From: Neil Crowther
Sent: 14 November 2014 13:01
To: Planning.Responses
Subject: FW: C14443 RE: Oldlands Farm - Surface Water Drainage Conditions BE/121/14 DOC

Further to your points raised in your email 22 October 2014 (attached for your reference) we would like to offer the following response.

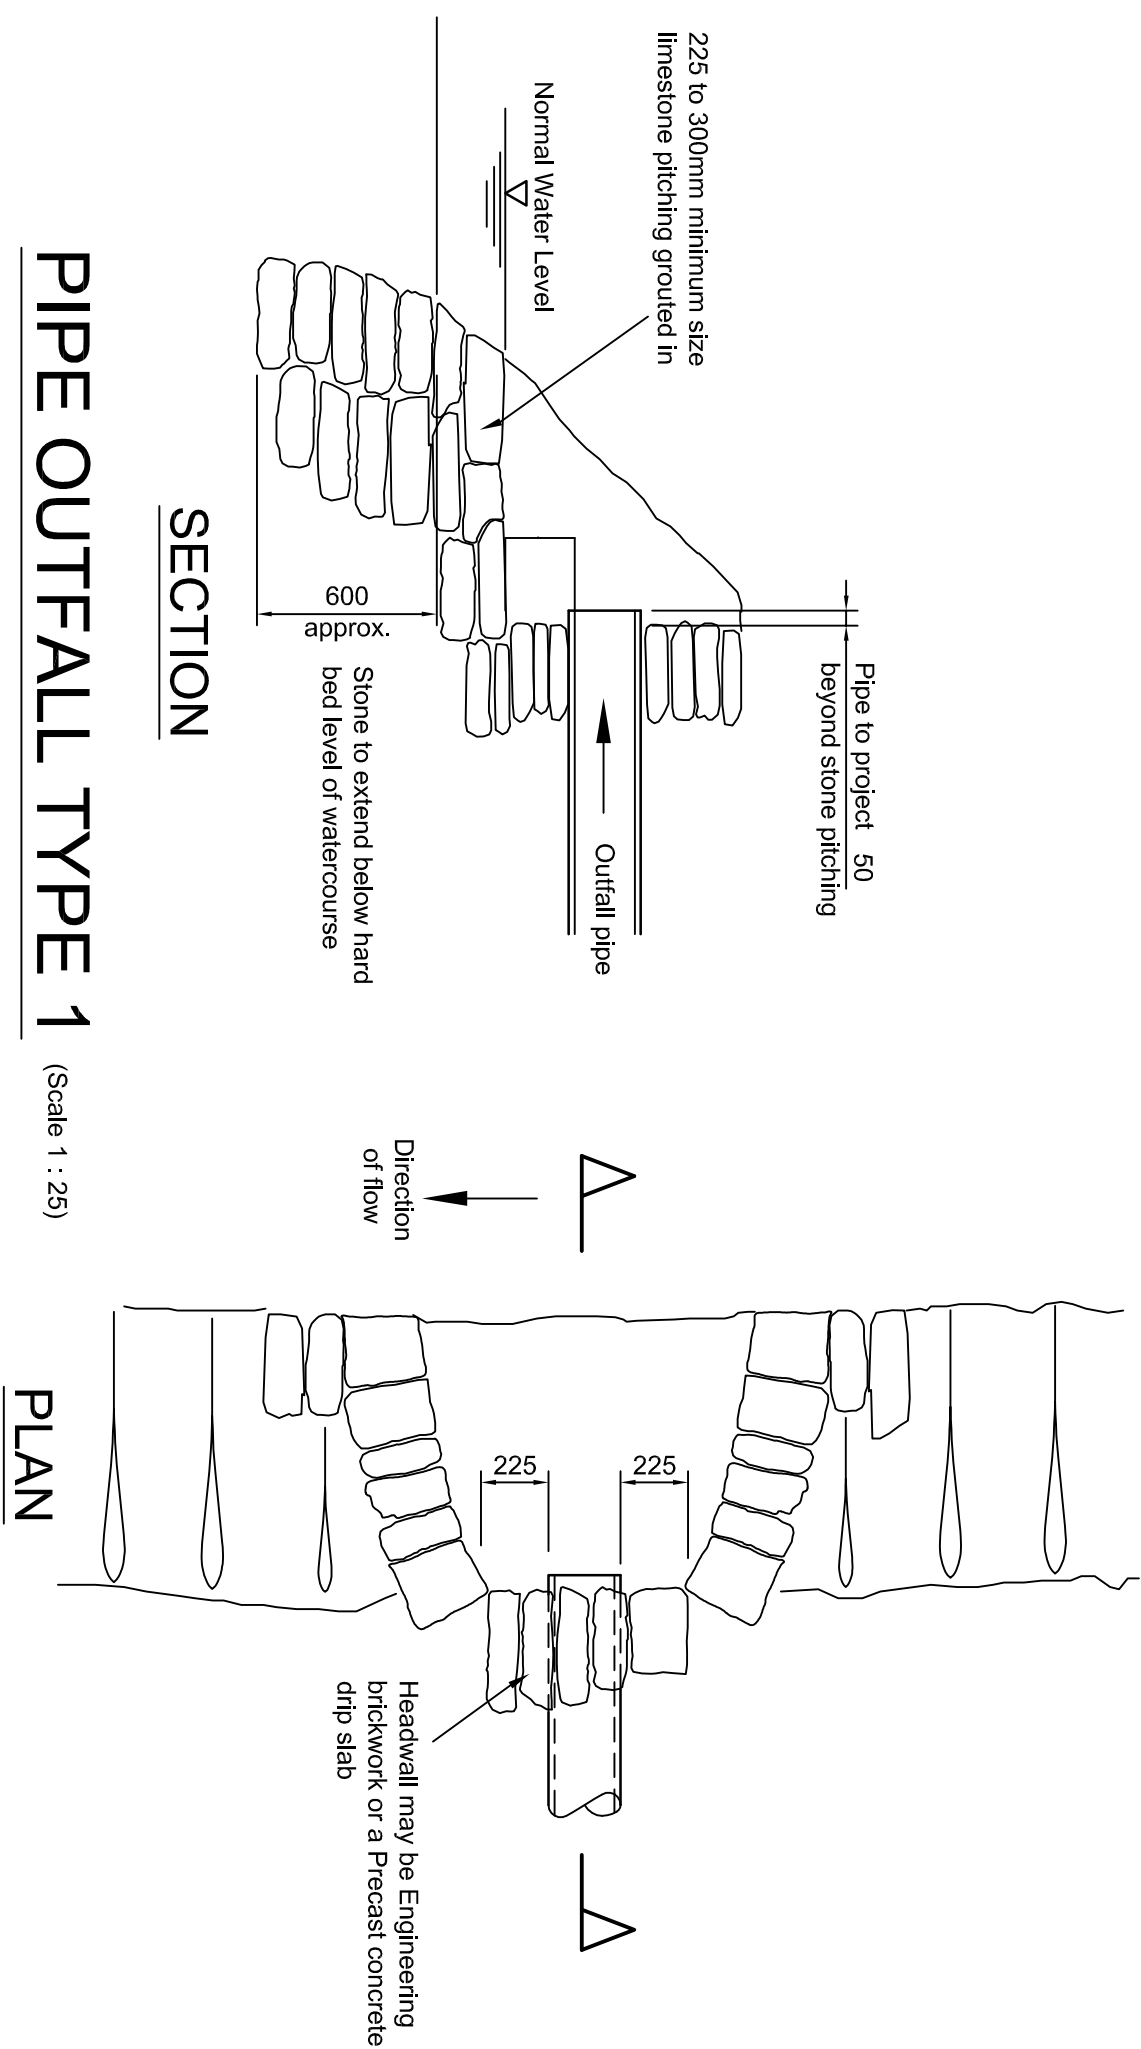
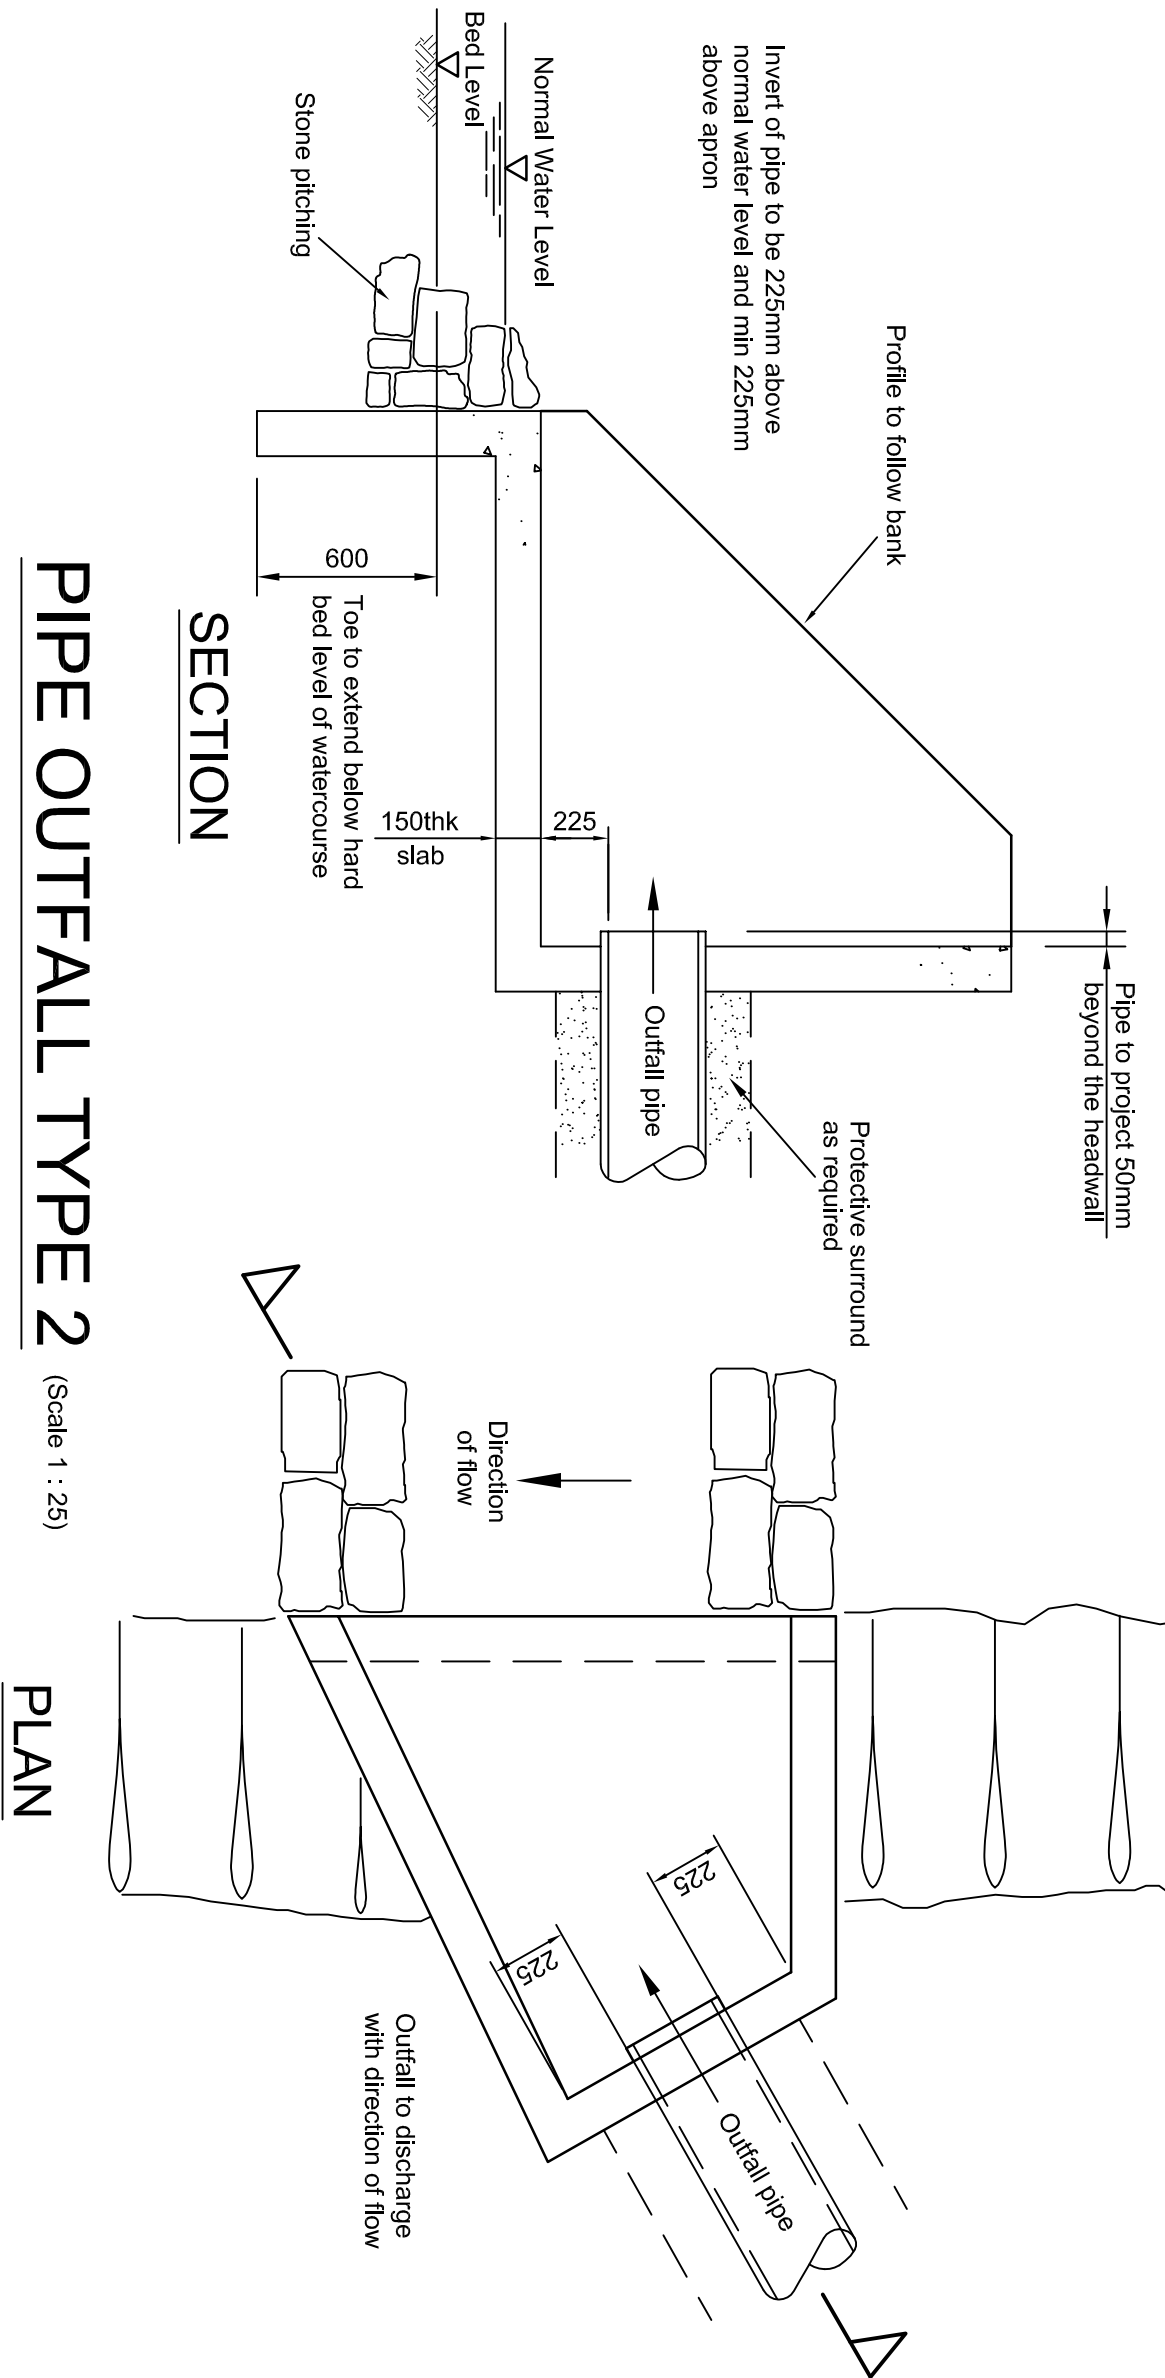
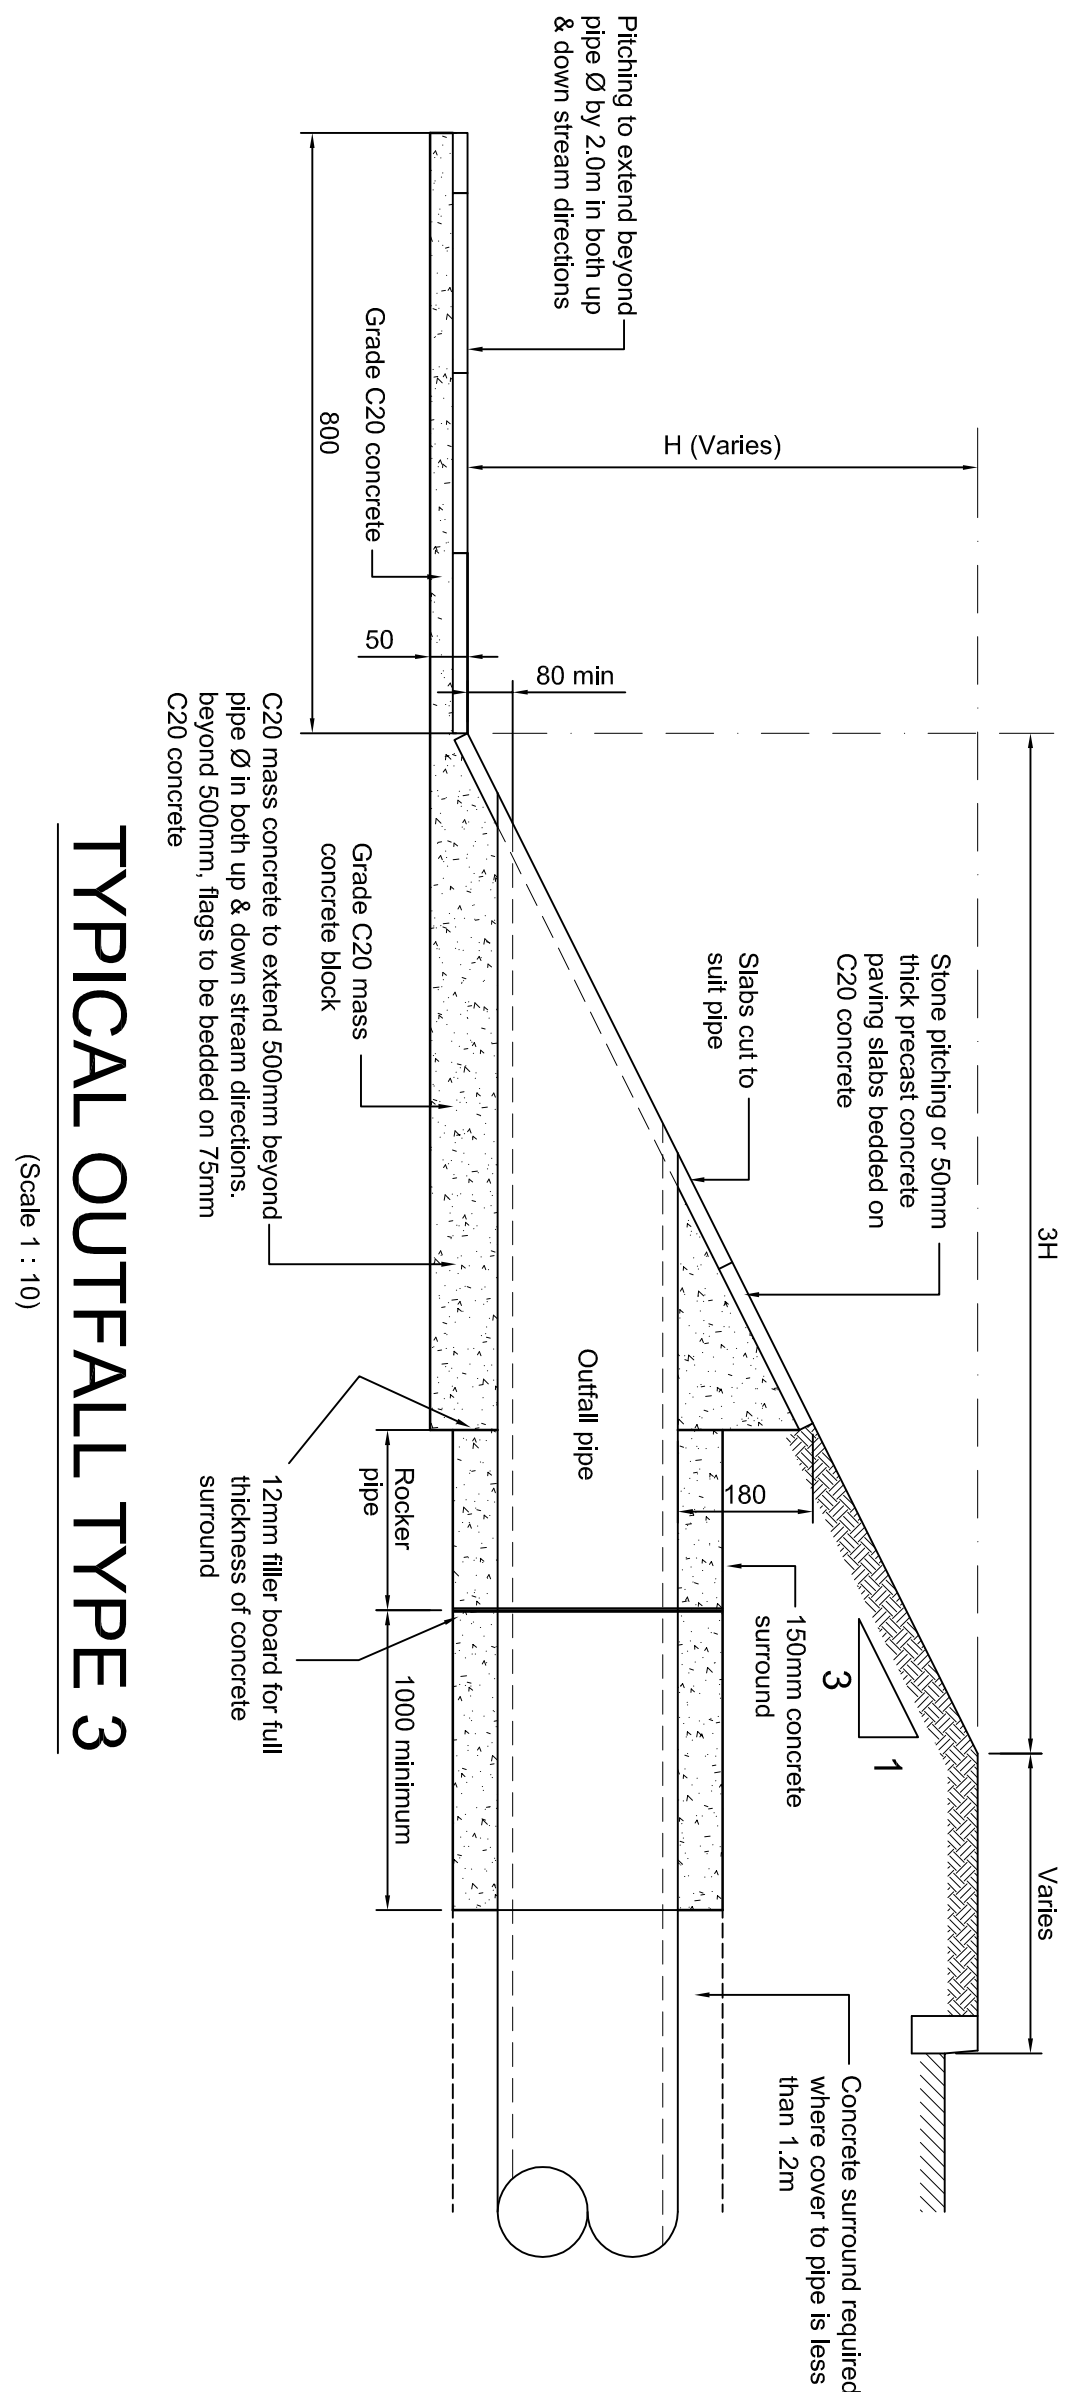
5. Outflow from pond to dry ditch has been angled further to direct flows into the channel.
6. The planning condition does not ask for construction drawings of the details you mention which will be submitted as part of the building control approval process. Drawing 220 attached gives outfall options for the contractor to price, it is likely that a precast outfall will be used. Given the nature of the ground, there will be no liner to the pond.
